Subject: Hatfield: Greta Nast Hyde Barn, Wilkins Green Lane; 16/1646/FUL & 1650/LB.

The site is within the curtilage of Great Nast Hyde and should be considered as listed because of its location and former use which was as threshing barn and also its current use, as storage associated and subservient to the House.

| Proposed Barn Elevations 1 & 2                                |   | 1547-P03-00         |                |             |

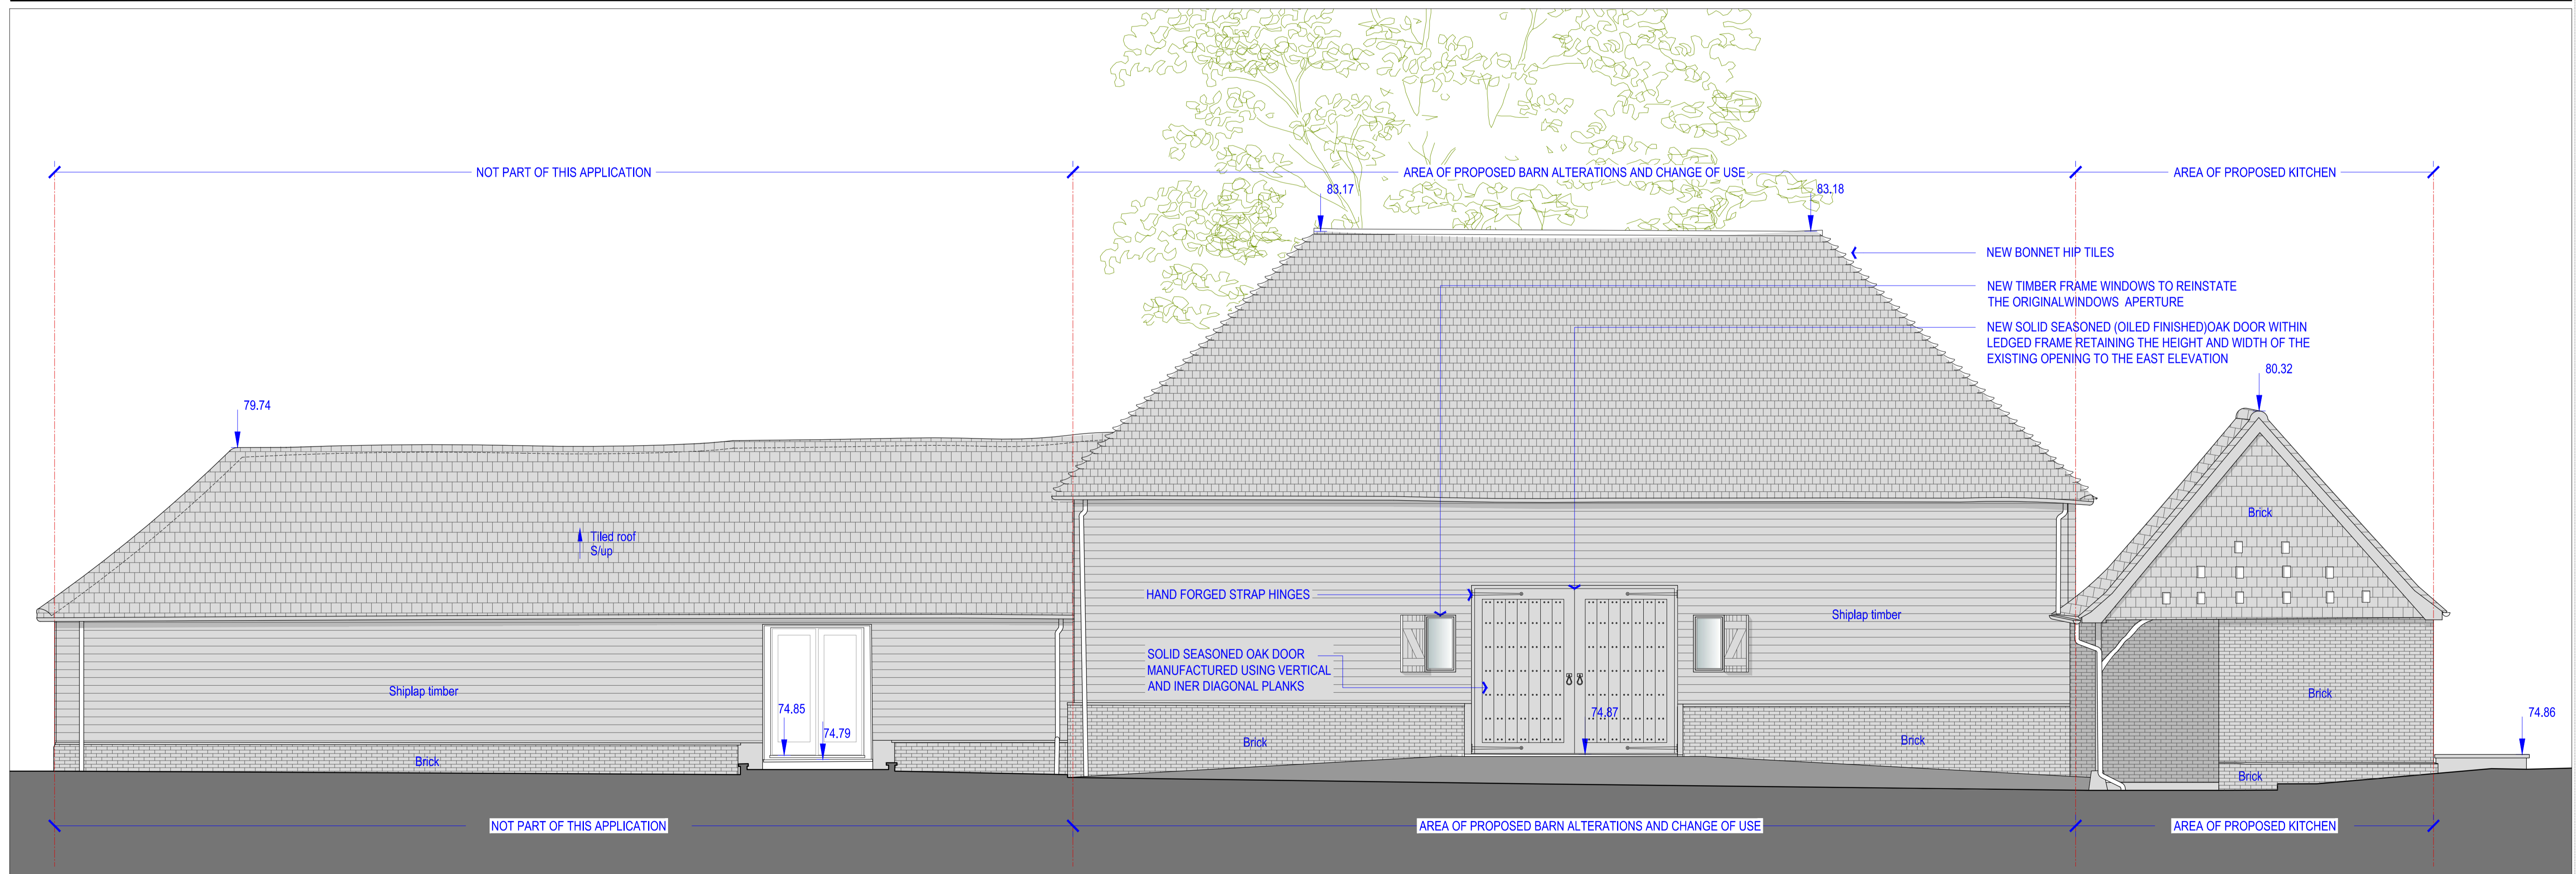
The application proposals would omit the internal glazed doors to the former cart entrances and proper

cart entrance doors would be introduced. The front doors would have a glazed fanlight introduced and

although this is not a typical feature of barn doors it would be a reasonable compromise in this case.

However, the evidence of the timber framing is that the original door opening was full height to the eaves and therefore the whole assembly should be heightened accordingly. Whilst the design of the doors would be satisfactory, it is more normal locally for the doors to have a central mid rail.

The proposed windows in the front and rear elevations would be into existing /previous openings and

would be so small as to not harm the overall character of the barn. However, the proposal to make a doorway into the end elevation of the barn would involve irreversible loss of historic fabric, including part of the brick plinth and timber frame including the sole plate which is an important member.

I would advise that we seek amended drawings to omit the new door to the kitchen and make

amendments to the barn doors and to the insulation as discussed. I have spoken with the Architect and he has intimated that they would be prepared to do this. In which case we would still need to apply conditions as follows:

DRAWING TITLE: Proposed Elevations 3 & 4

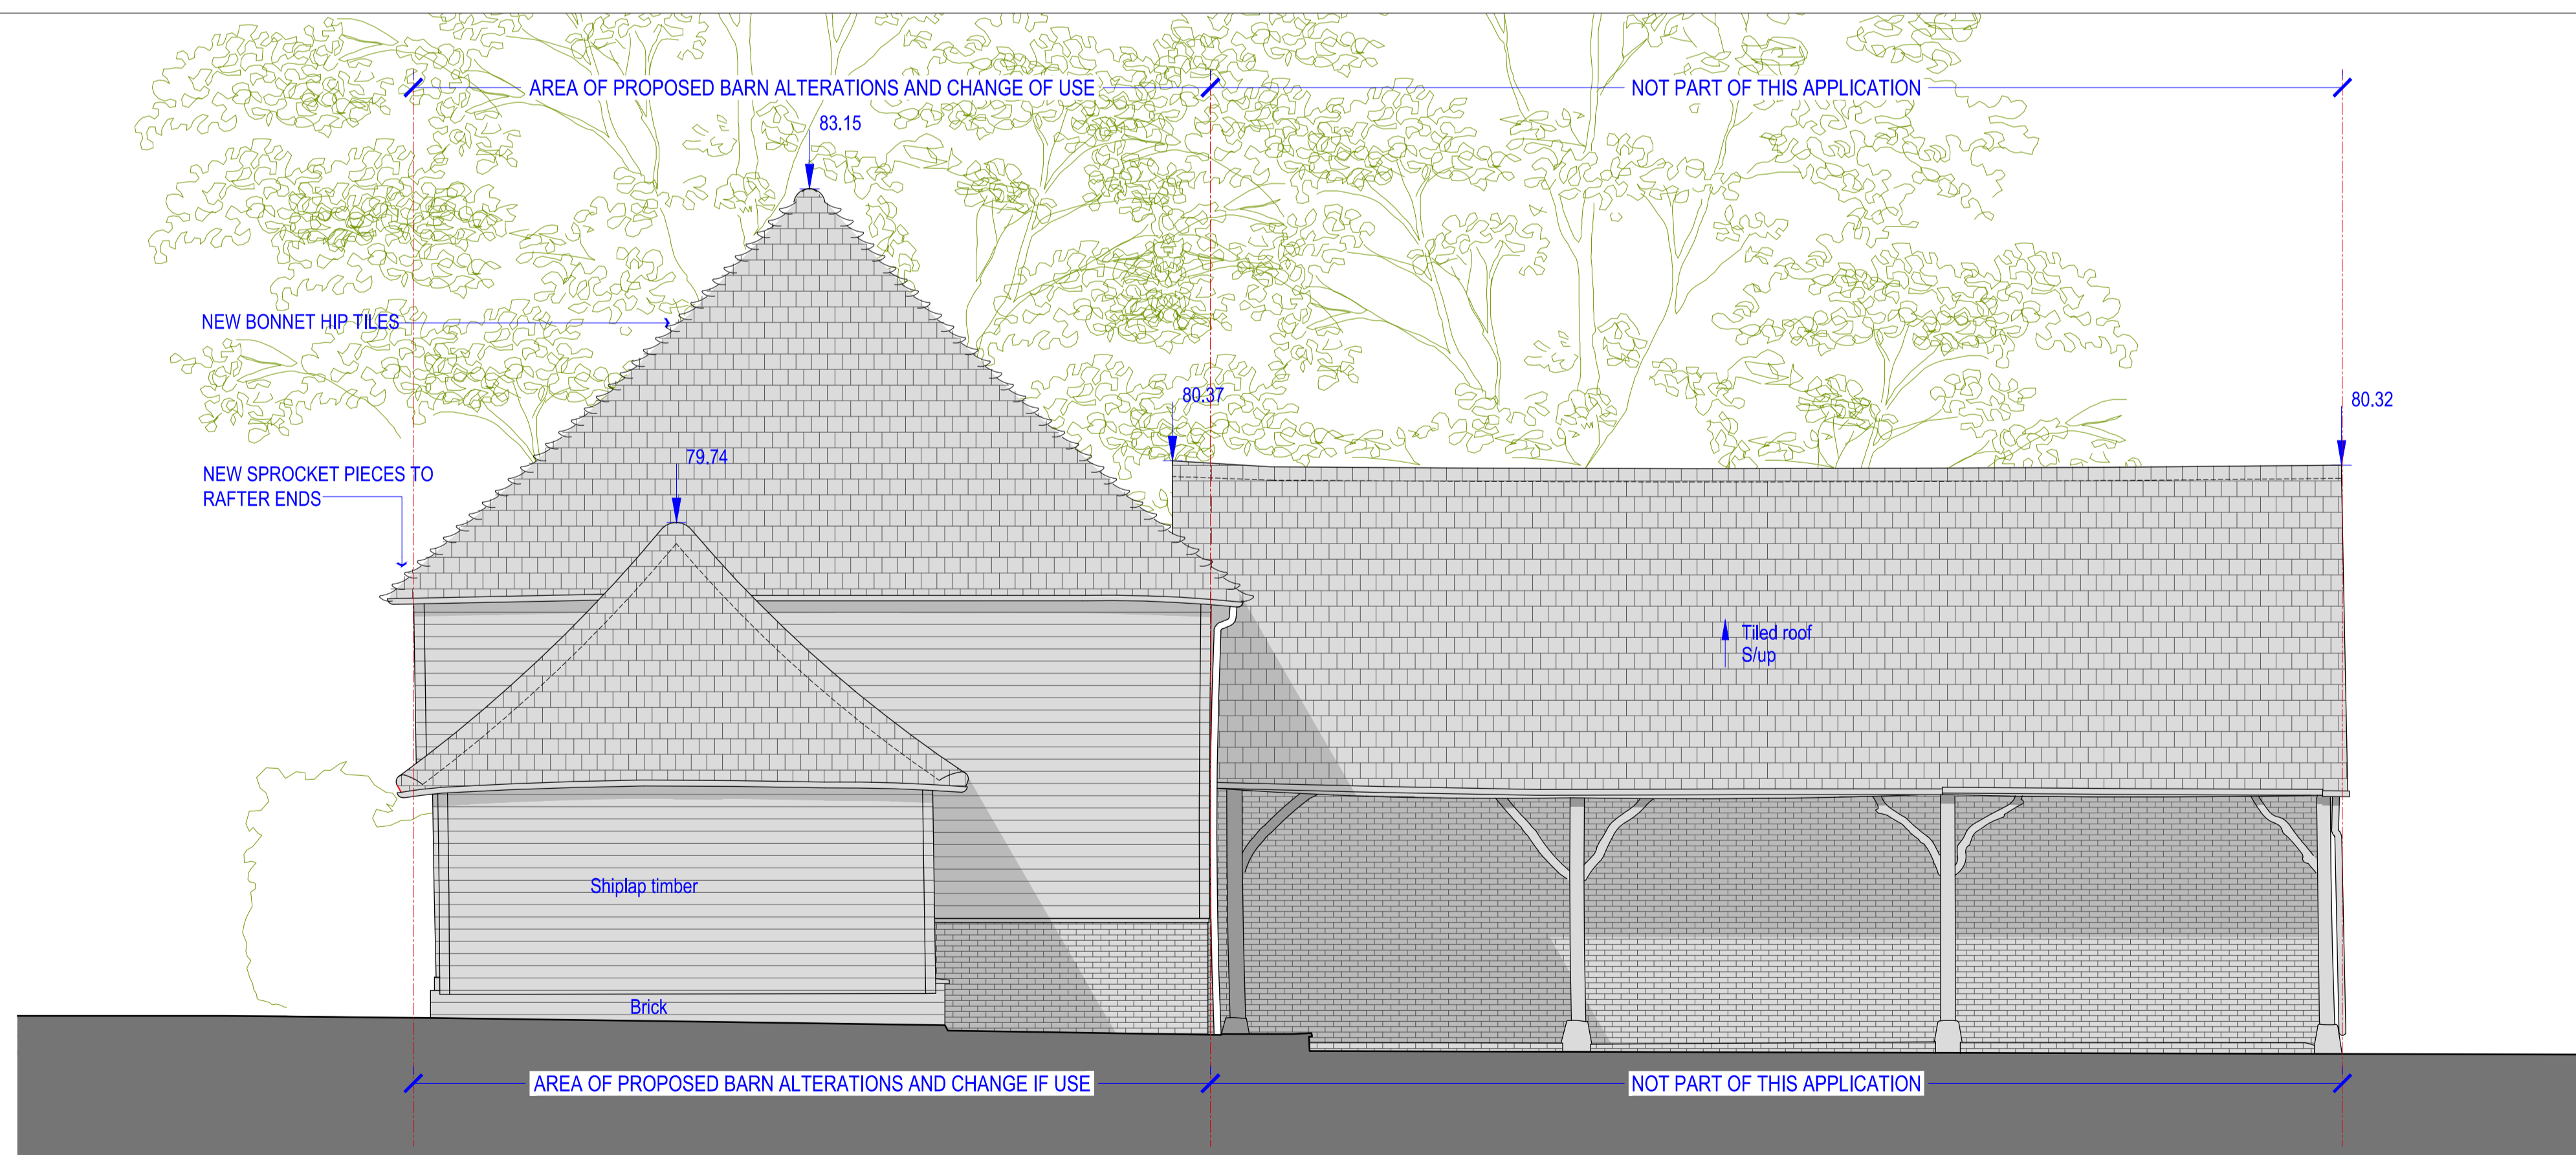
The alternative to this would be to utilise one or more of the existing window openings in this elevation

as serving hatches, which would avoid the harm and be a reasonable compromise. The heritage statement also advises that the door would also give "disabled access", However, it would be preferable

ISO-A1	CLIENT:	VIVENDI ARCHITECTS LTD	PRIVATE CLIENT
	PROJECT TITLE:	GREAT NAST HYDE HOUSE, WILKIN'S GREEN LANE, HATFIELD AL10 9RB	
	DRAWING TITLE:	Proposed Barn Sections	
	JOB AND DRAWING NO.:	1547-P04-00	
DESIGNER:	CK	STATUS:	PLA
SCALE AT A1:	1:50	REVISION:	P1

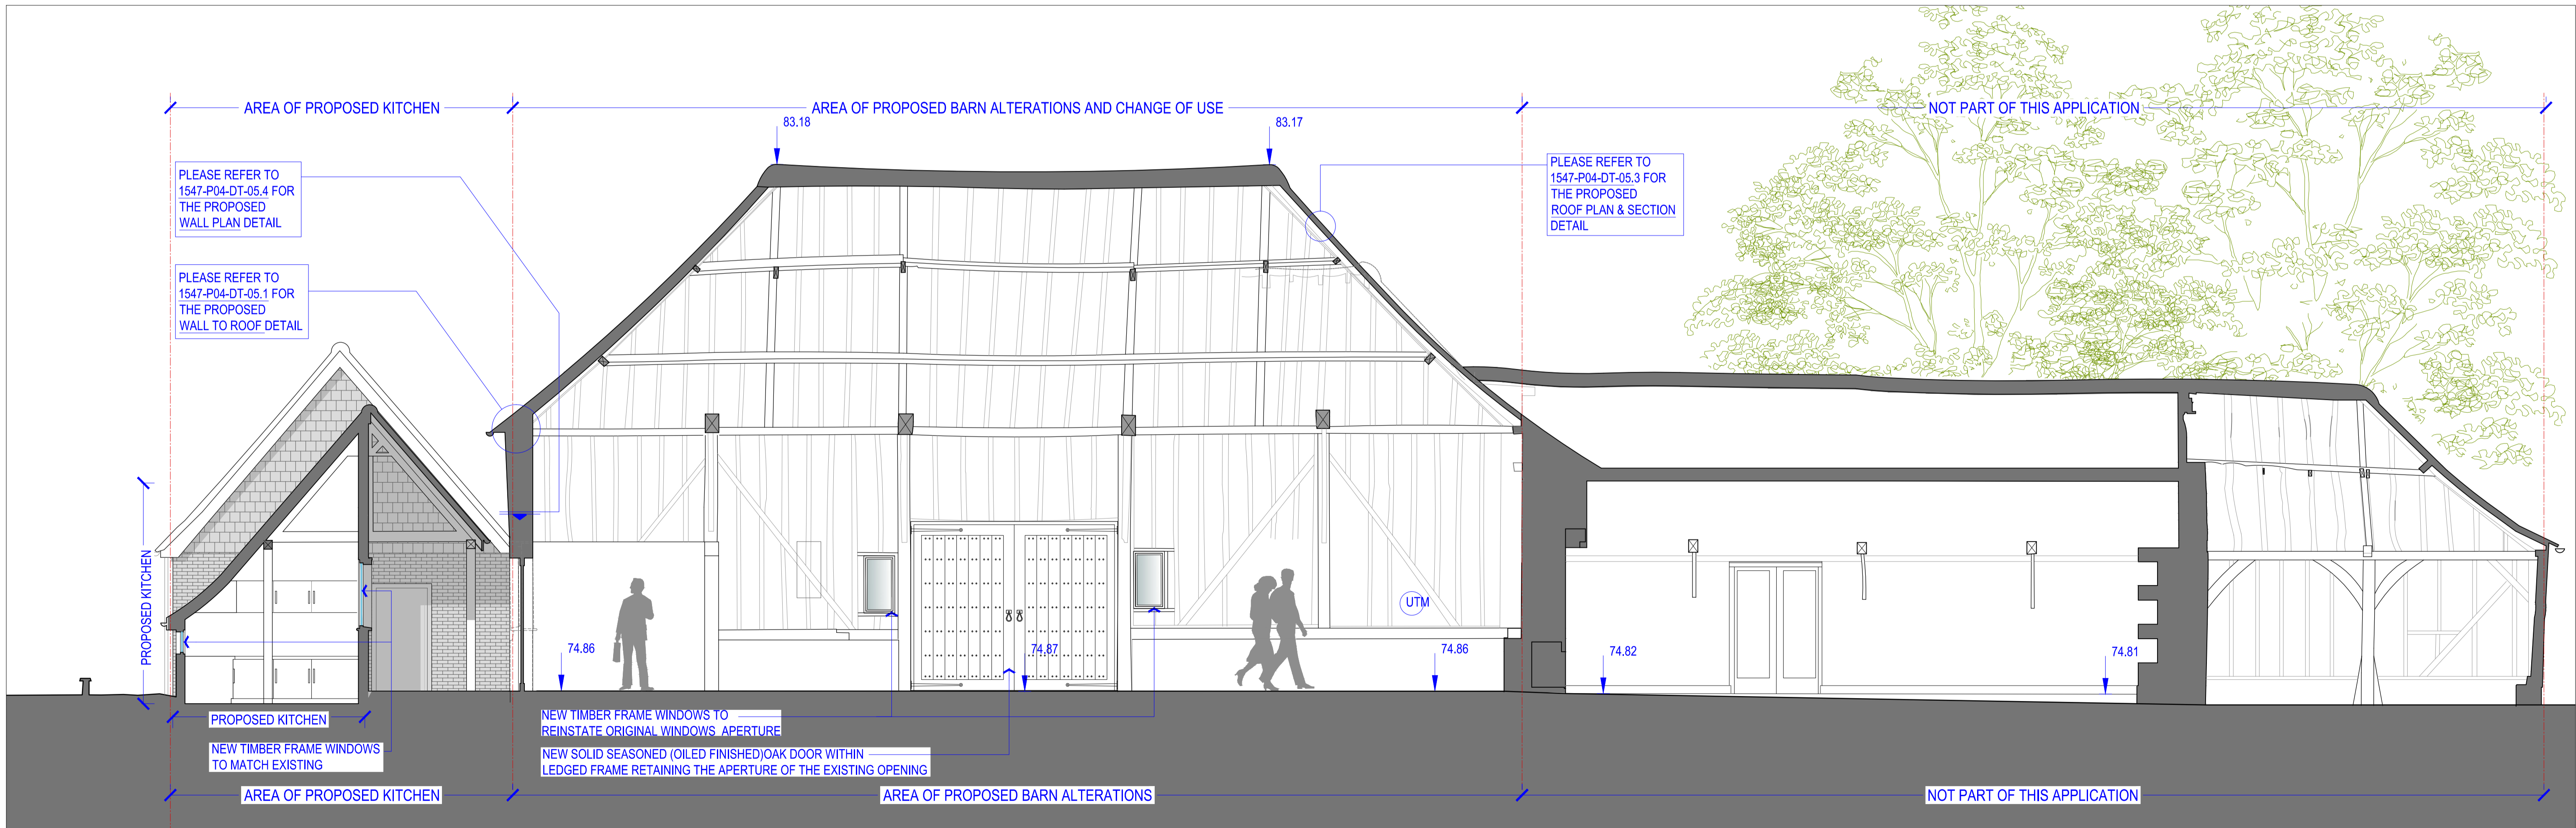
It is proposed to insulate the barn. This has the potential to have an adverse effect on the internal character which as is typical, relies to a great extent on the intricacies of the timber frame and the rustic

finish of the inside of the weatherboarding. In this case, as the use of the building would be intermittent,

it is proposed to limit the width of the insulation and to locate it partly externally and partly between the timber frame. However, the set back would be minimal and given the uneven section of the frame,

would in some cases be nil. For these reasons, I would advise the omission of the front counter batten and the internal batten to which the internal cladding is fixed ( which could be replaced by a plastic angle). This should give a nominal 50mm recess to the internal cladding, which would better define the timber frame. Insulation should be breathable but this could be subject to condition.

The drawings give no indication of how the floor is to be dealt with.. At pre-application stage, a replacement insulated floor was put forward. However, the site investigation has now shown that an historic clay floor lies beneath the modern concrete slab and therefore it would be preferable to work

The roof is shown to be fitted with bonnet tiles to the hips and , whilst this is a nice detail, there is no

evidence that it was historically used here and barns in this area normally use ridge tiles in this situation.

[03] Hand Drawing Elevation Details of Disabled Barn Door to the North-West @1:20

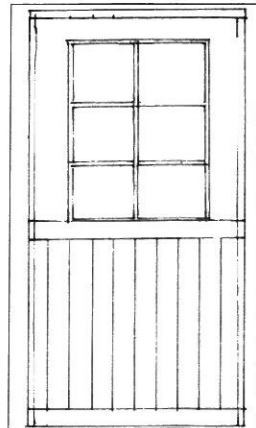
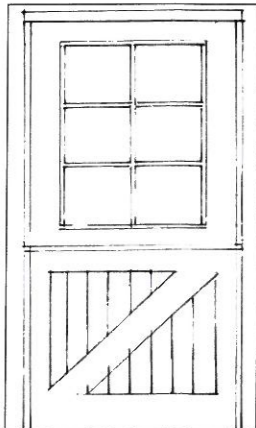
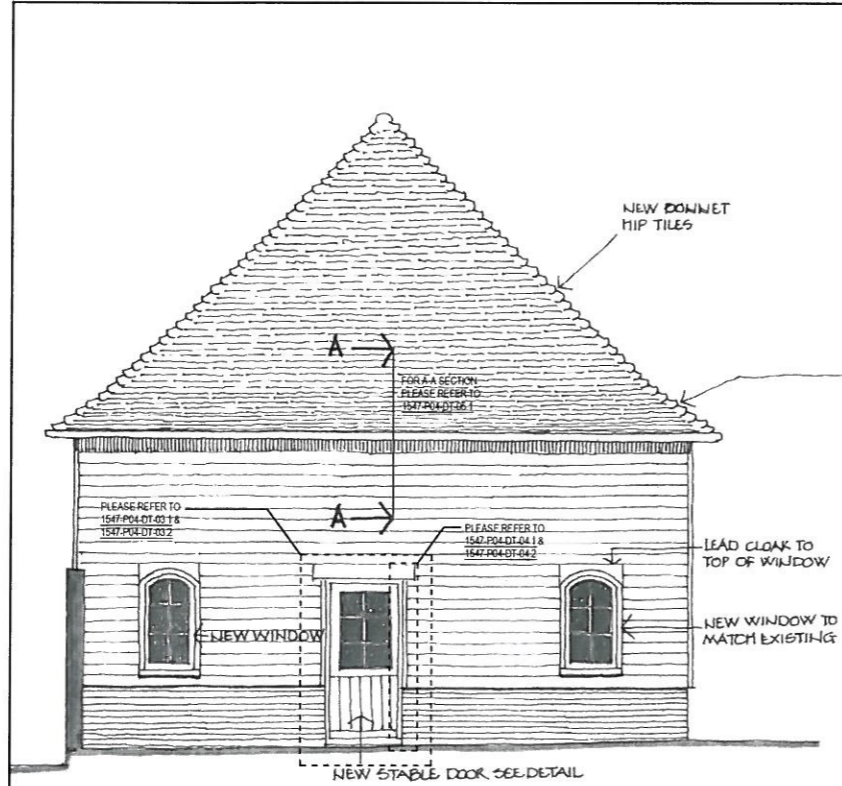
for this to be from the main entrance so as to be more truly inclusive as well as less damaging to the historic fabric. The general and "disabled" access could be made more convenient by fitting one of the
